ENG-SF22001-R1-CDs.pdf Markup Summary

SF-22-001

SHEET NUMBER
C0.1
TOTAL SHEETS: 18

SHEET NUMBER
C7.1

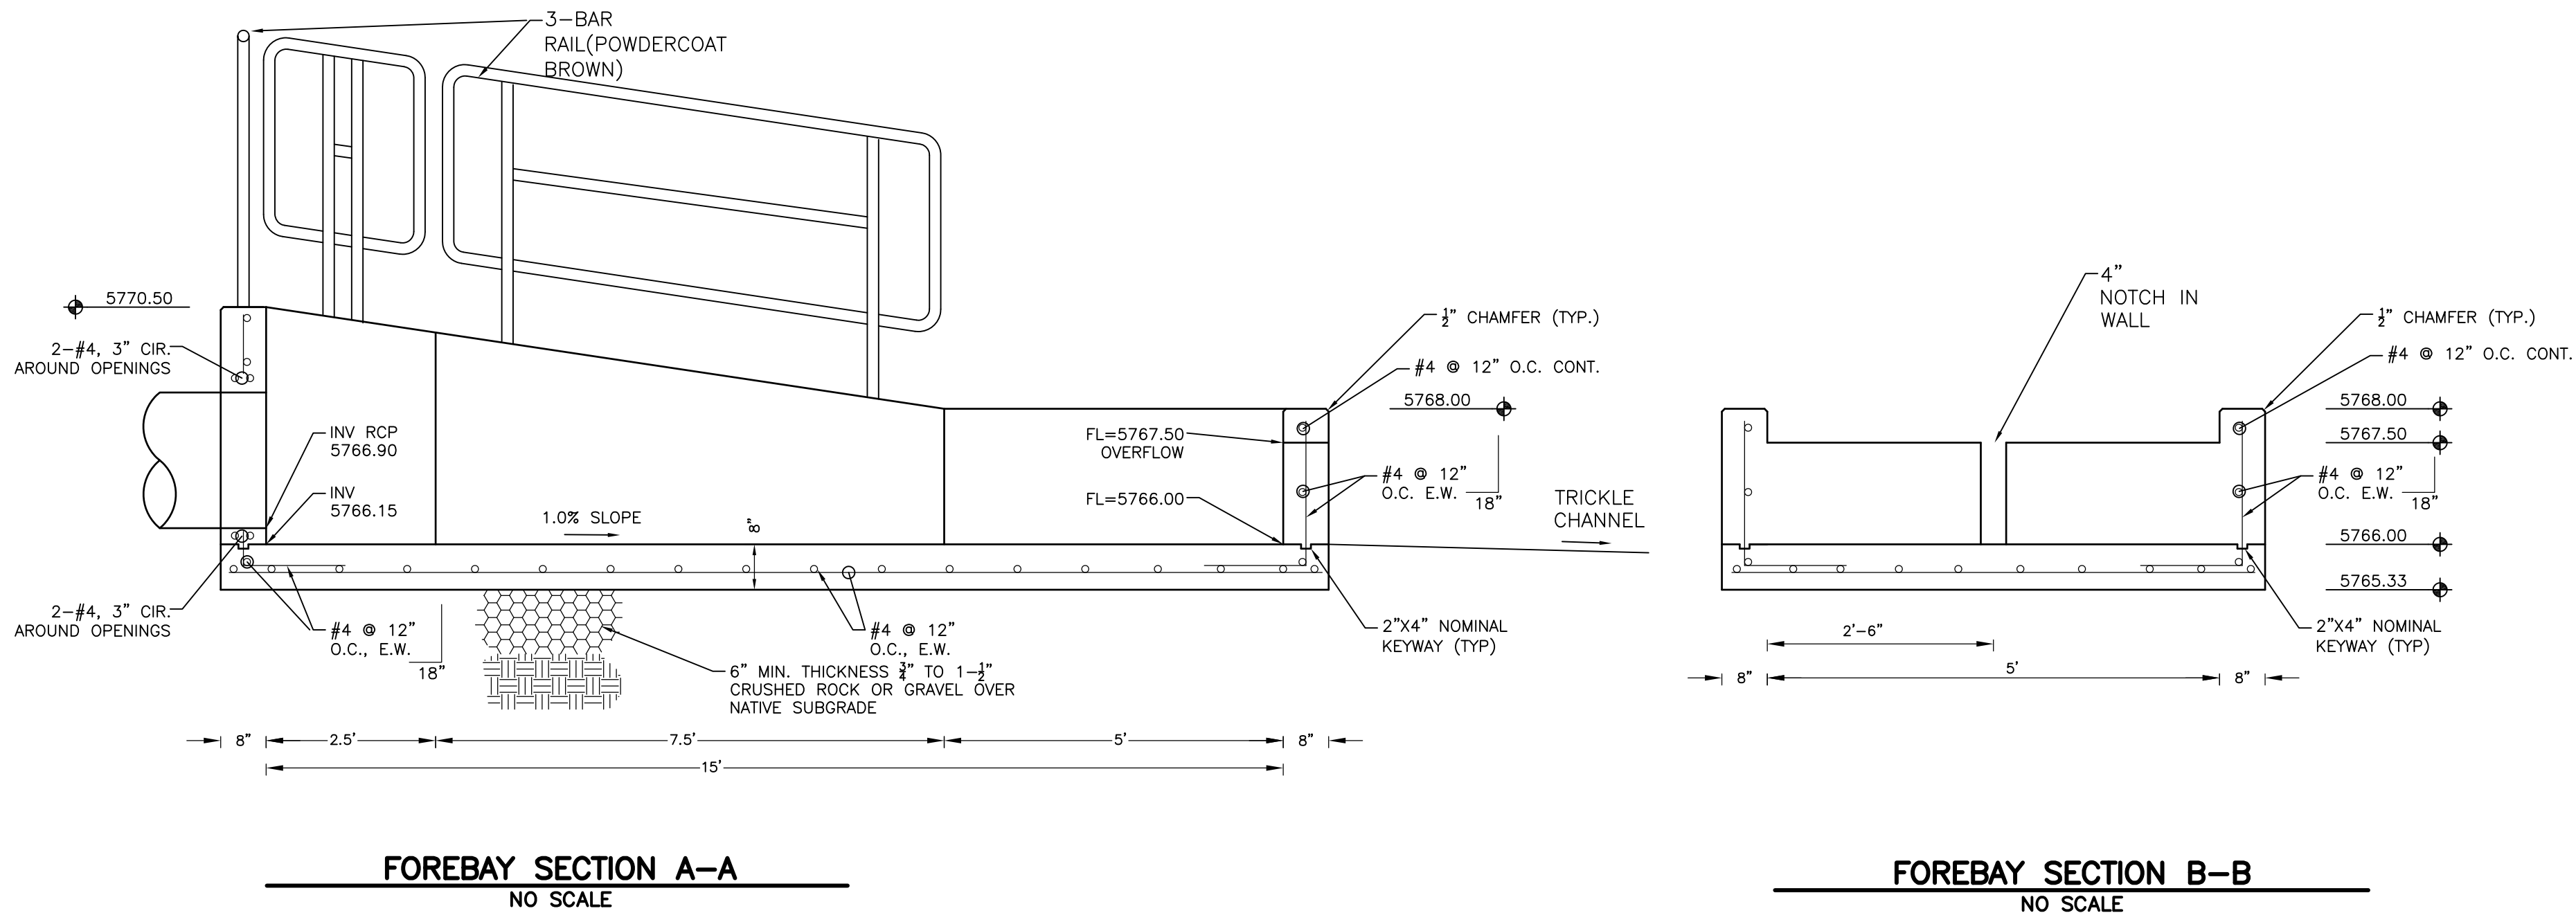
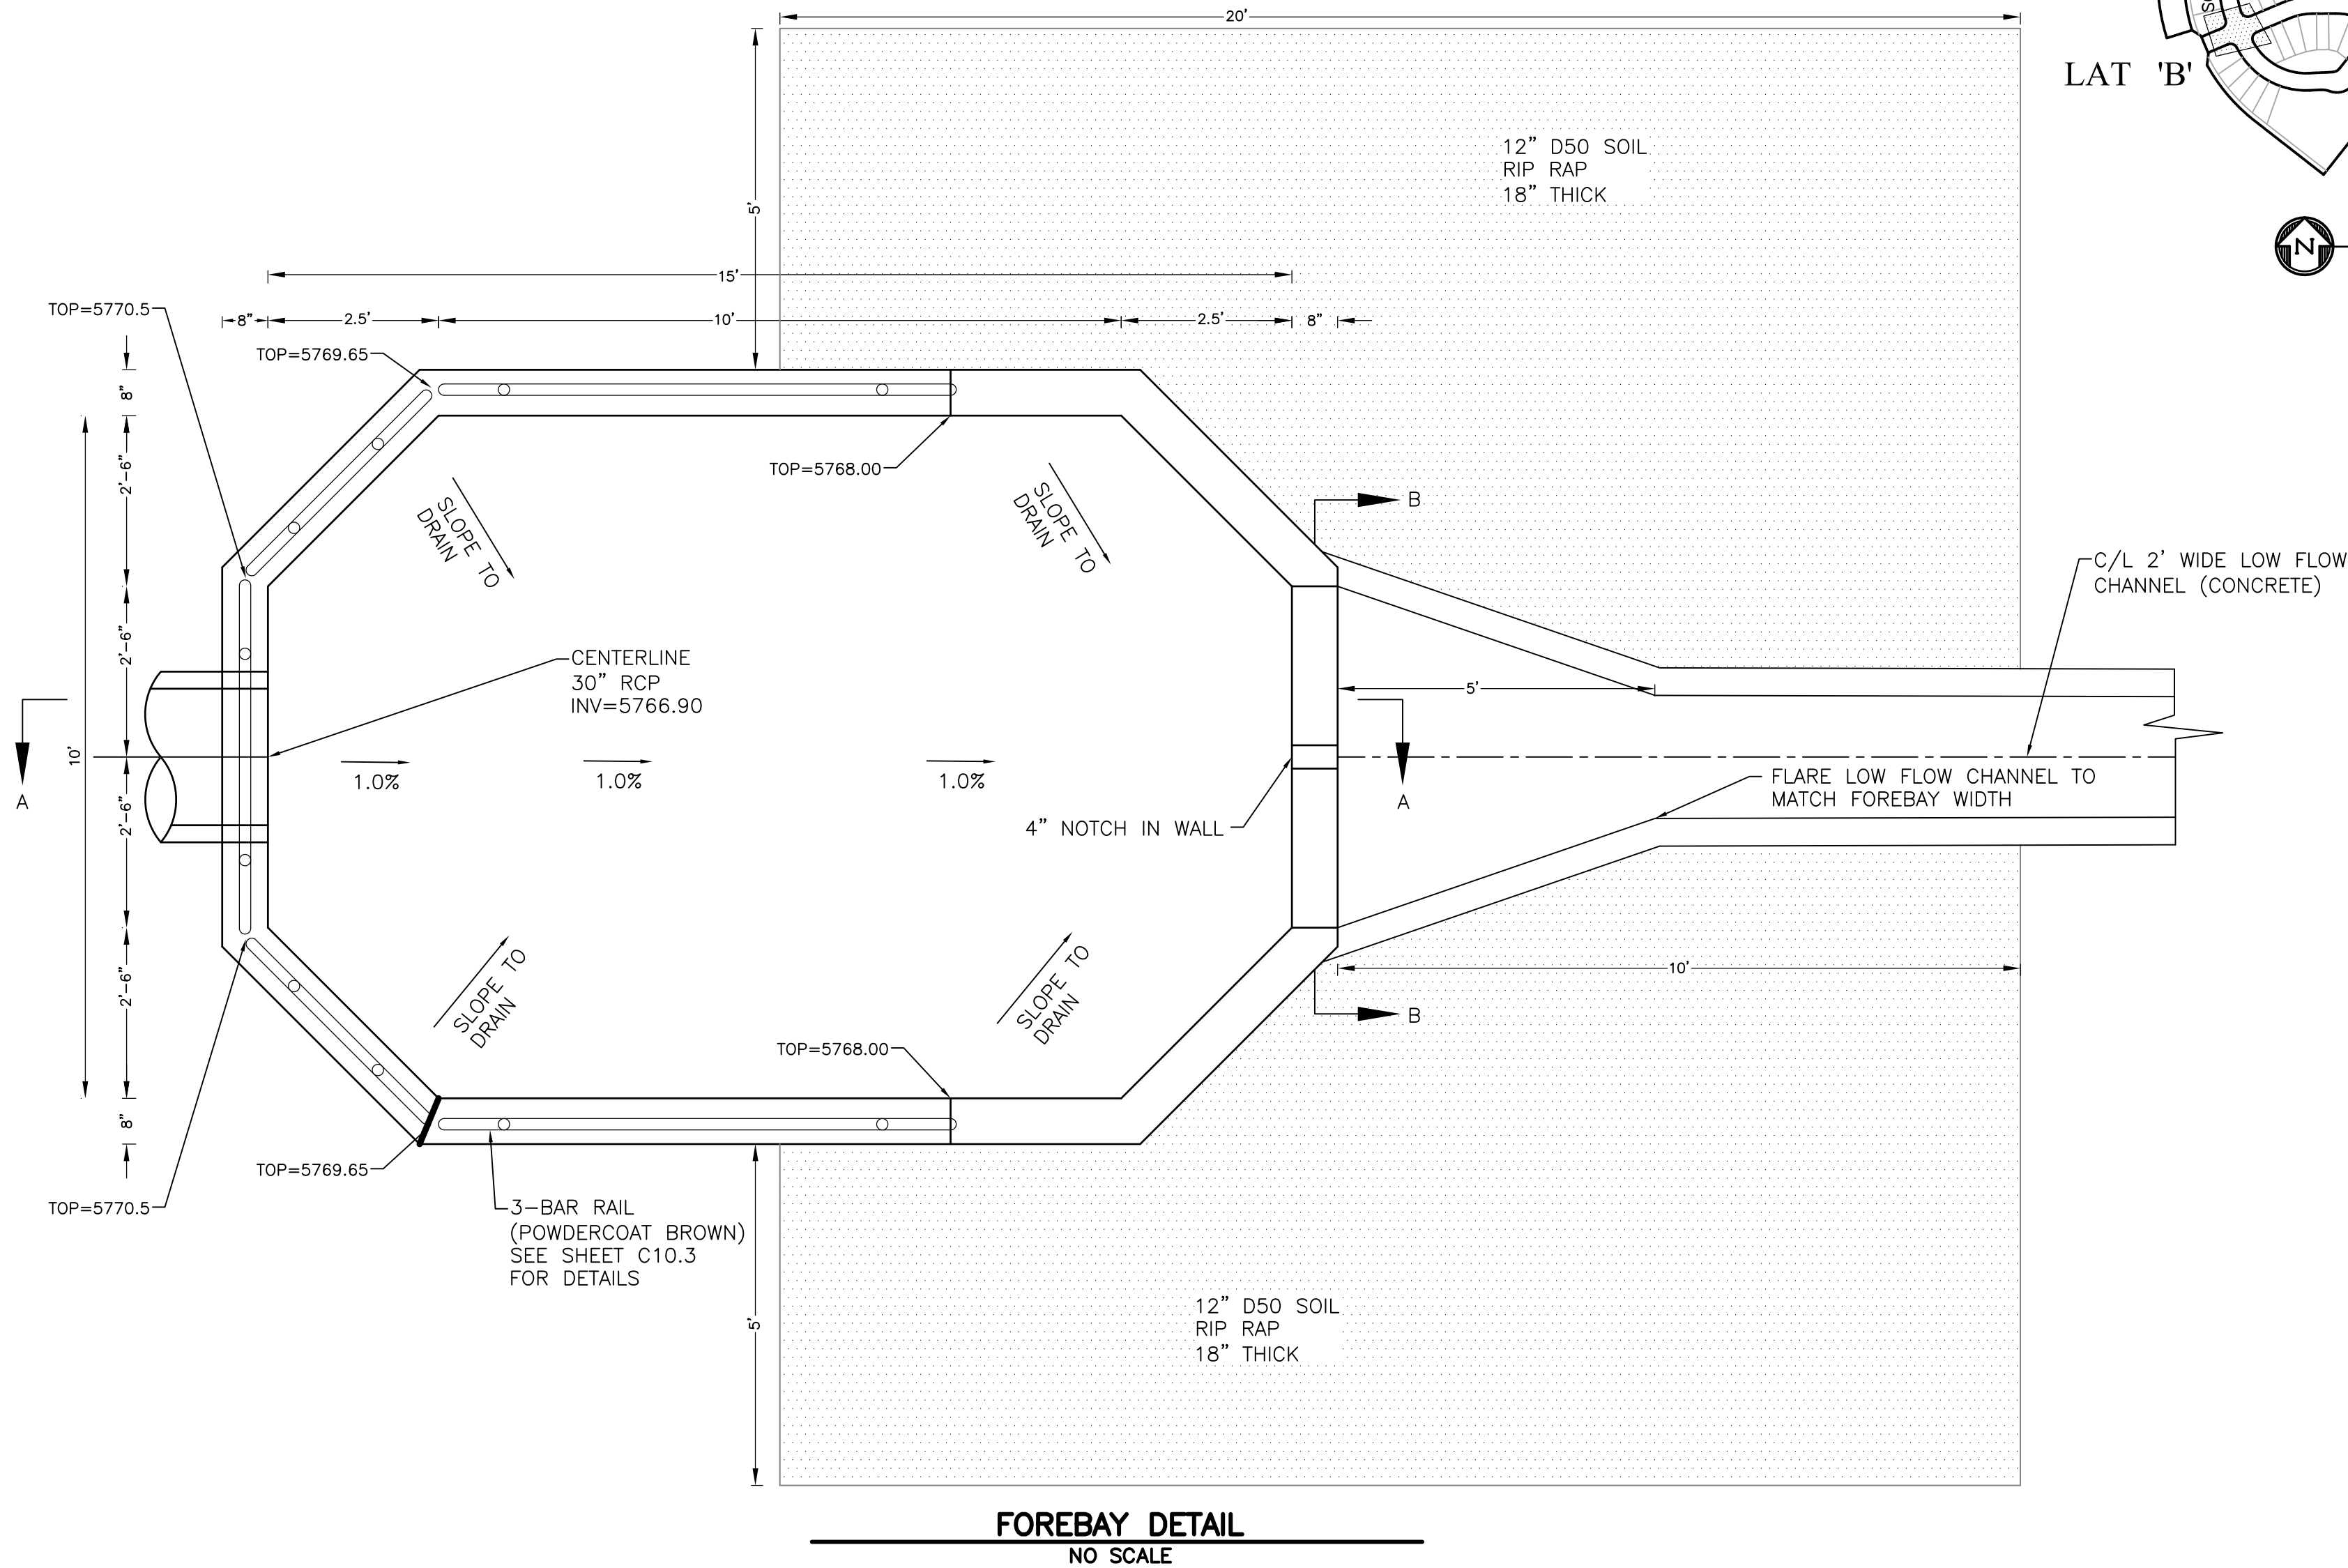
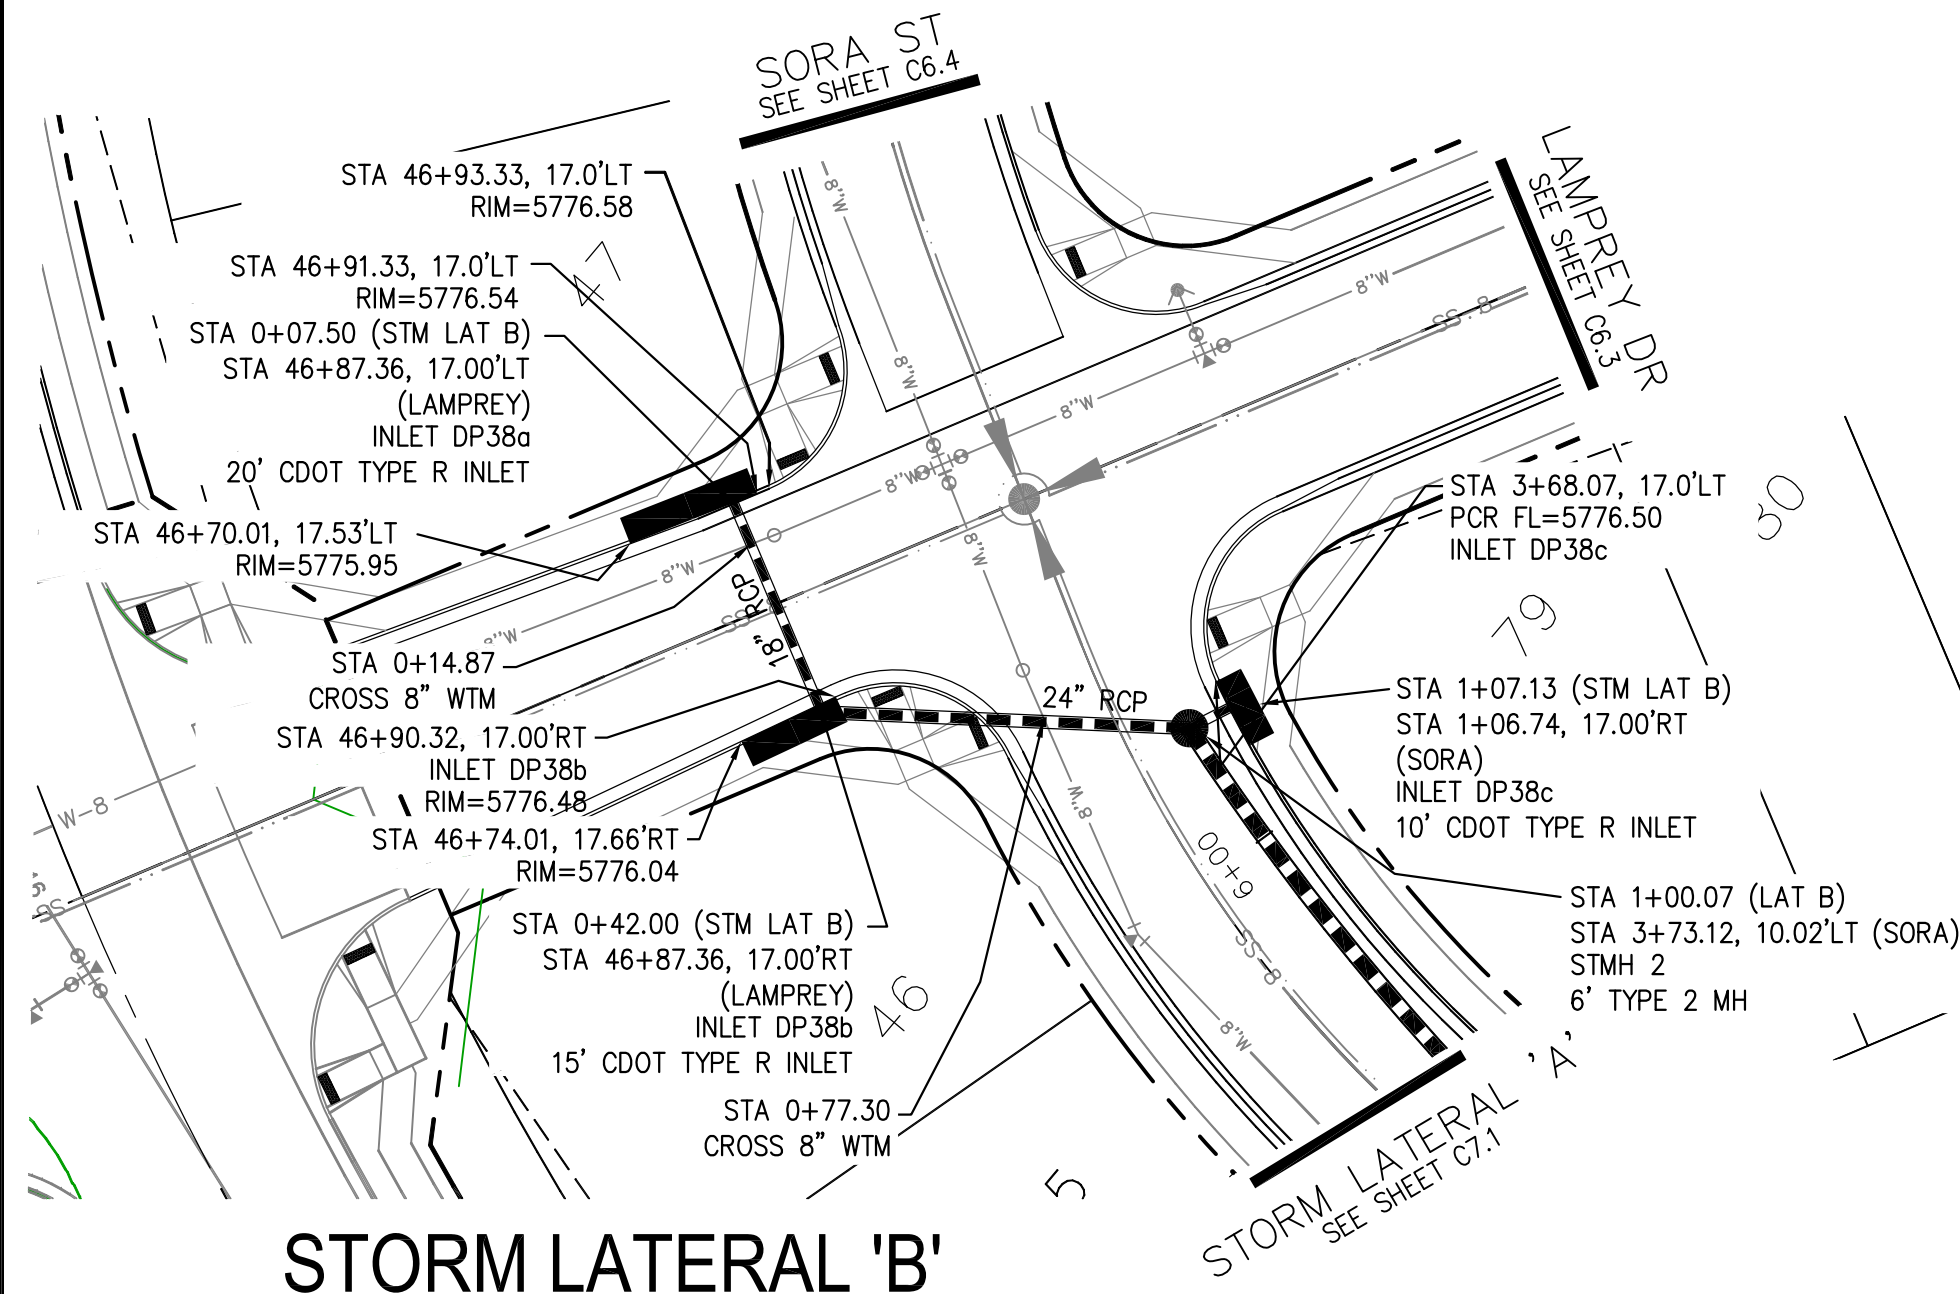
Page 46 of FDR states that this orifice should be 5.16" high x 22" wide.

There is also supposed to be a 2nd rectangular orifice of 6" x 22"

provide forebay sizing calcs in FDR.

Soil Riprap: Specify installation instructions and mix ratio for soil riprap. As an example, note: "Per MHFD Spec Section 31-37-00, the soil material shall be native or topsoil and mixed with 65% riprap and 35% soil by volume. And soil riprap shall consist of uniform mixture of soil and riprap without voids." And specify the riprap type per Table 1 of that spec.

Per MHFD USDCMv2 Chap 9, Section 3.2.4 (pdf pages 89 to 99), forebay baffles are required for inlet pipes up to 48" diameter.
